CITY OF ALBUQUERQUE

**Re: Ace Leadership High School
1225 Sawmill Rd NW
Request 90 day Temporary C.O. - Accepted
Engineer's Stamp dated: 4-3-14 (J13D099)
Certification dated: 1-19-15**

**RE: ACE Leadership High School -1225 Sawmill Road NW
Proposed Drainage Management Plan and Grading Plan For
For Building Permit and Work Order
Engineer's Stamp Date 4-3-2014 (J13/D099)**

RE: **ACE Leadership High School - 1225 Sawmill Road NW**
Drainage Management Plan and Grading Plan for
Building Permit, SO-19 and Work Order

C-300

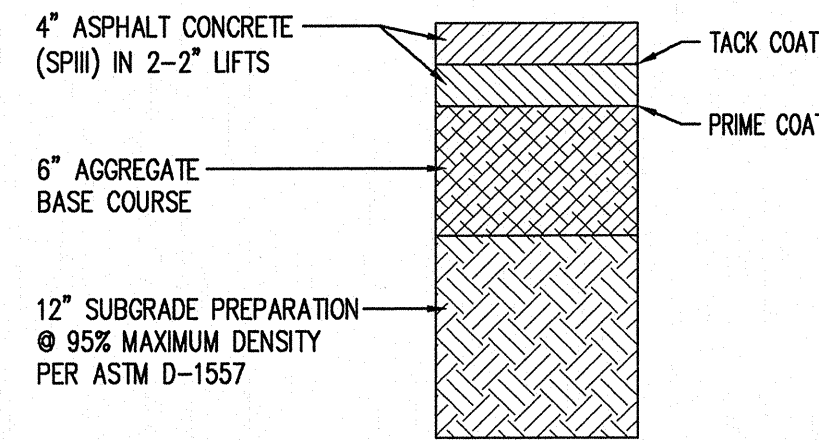
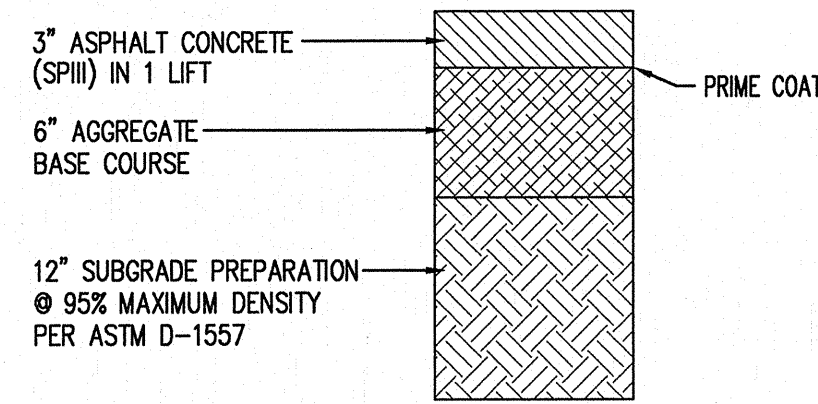
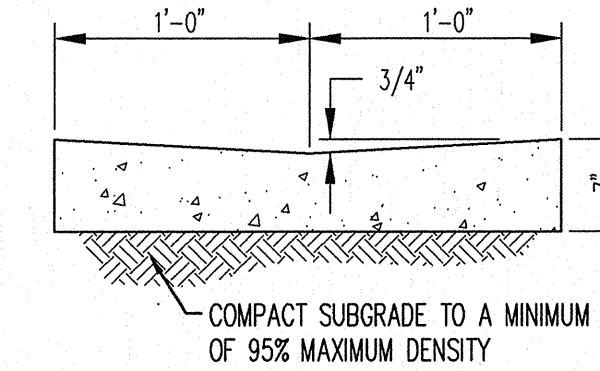
1. The DMP sheet should include a location map (J13) and applicable FIRM map, identifying the Flood Zone applicable to this site.
2. Clarify that the impervious areas used in sizing the ponds includes the Gravel roadway surfaces. If not, boldly note on the DMP and Grading Plan that hard surfacing of those areas will require reanalysis and possible pond size adjustment.
3. What surfacing is proposed on the Cul-de-Sac? Label if it is in the Work Order.
4. What is the typical gravel road section? - Curb & gutter on sides?
5. On the G&D, does the Perimeter Retaining/Screen wall prevent cross lot drainage?
6. How does the SE entrance tie to Sawmill Road?
7. How do you know the invert elevation on the SD Manhole full of dirt?
8. Label all items to be built by Work Order, and reference the CPN.
9. The SO-19 notes will not be applicable, since the work on Sawmill is in WO.

- ✓ 4. The gravel road is 24 feet wide (F-F) with 6" of base course on prepared subgrade. A gravel pavement section is shown on Sheet C-300.
- ✓ 5. The perimeter fence on the south and west sides are 8 foot high CMU and will prevent cross lot drainage. The grades around the remainder of the site are set to so that all onsite drainage is conveyed to the detention pond and will not drain onto the adjoining properties.
